Ribble Valley Borough Council Development Control Council Offices Church Walk Clitheroe Lancashire BB7 2RA Our ref:NO/2023/115101/01-L02Your ref:3/2022/1158Date:23 March 2023

ERECTION OF 17 DWELLINGS AND 57 APARTMENTS WITH ASSOCIATED ACCESS, ROADS, CAR PARKING, LANDSCAPING AND INFRASTRUCTURE, INCLUDING A PUBLIC CAR PARK TO SERVE WHALLEY TOWN CENTRE LAND SOUTH OF ACCRINGTON ROAD, WHALLEY

ATTENUATION BASIN DETAIL

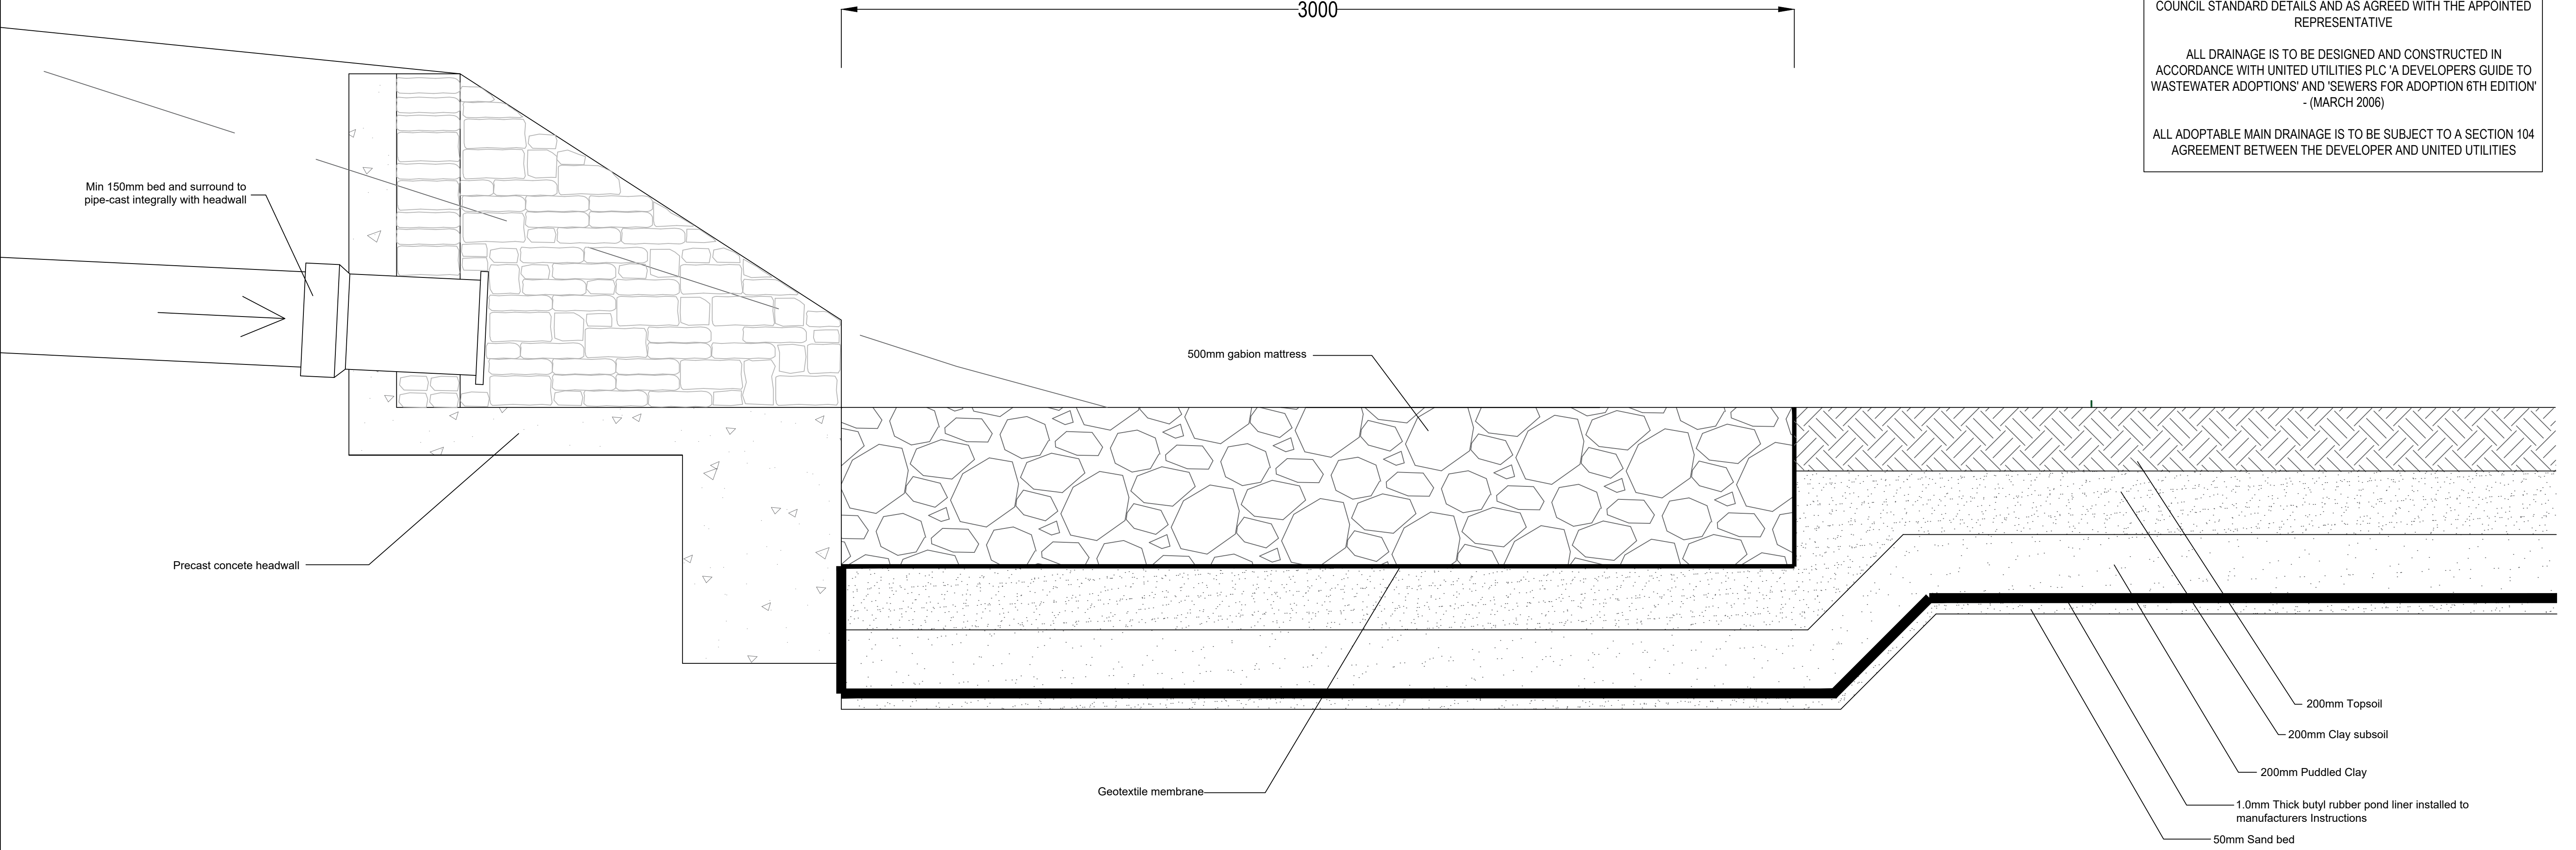
The design of the compensatory flood storage area and attenuation basin as shown on Phase 1 Drainage Layout drawing 21315 GAD 01 ZZ DR 1001 Rev. P04, while likely to be volumetrically accurate, is unnaturally angular in shape, with almost entirely straight edges. While this aspect is an aesthetic observation, the very slender neck of land between the attenuation basin and the compensatory storage area is a concern from an engineering, maintenance, and regulatory perspective.

There are no indicative dimensions provided on the drawing, but in comparison with the scale of other known details (standard car parking space width assumed 2.4m), this would appear to be only around 1 meter wide. While engineering construction details are not provided at this stage, such a design would appear to promote an unacceptable risk of breach between the attenuation basin and compensatory flood storage area and vice versa. In addition, while access requirements between the attenuation basin and compensatory storage area are not known, such a design would certainly preclude the use of ride on plant for maintenance and repair.

The design currently proposes 5 No. 225mm diameter outfalls with non-return (flap) valves arranged in series on the internal southern face of the compensatory storage area and out falling on the riverbank of the river Calder. The Environment Agency has considerable experience in drain down structures on flood defences and flood storage areas, and we consider the solution currently proposed less than optimal in design terms.

The pipe diameters are small and there are 5 in total. These pipes will be prone to blockage and obstruction for materials arising or been washed or carried into the flood

storage area. There is also the potential for willful obstruction. The flaps on the riverward side could also be prone to obstruction or damage, and because of their small size and low mass, together with their orientation parallel with the river, are likely to flutter, catch debris and not close properly when required to. The number of pipes, their component parts and their position would make maintenance and operation checks burdensome and has potential to detrimentally affect the functionality of the proposed compensatory storage area.

Our recommendation would be that the designers consider a single, larger, grilled and flapped inlet and outfall with an auxiliary drain down penstock. The outfall should be angled downstream rather than parallel to the flow of the river.
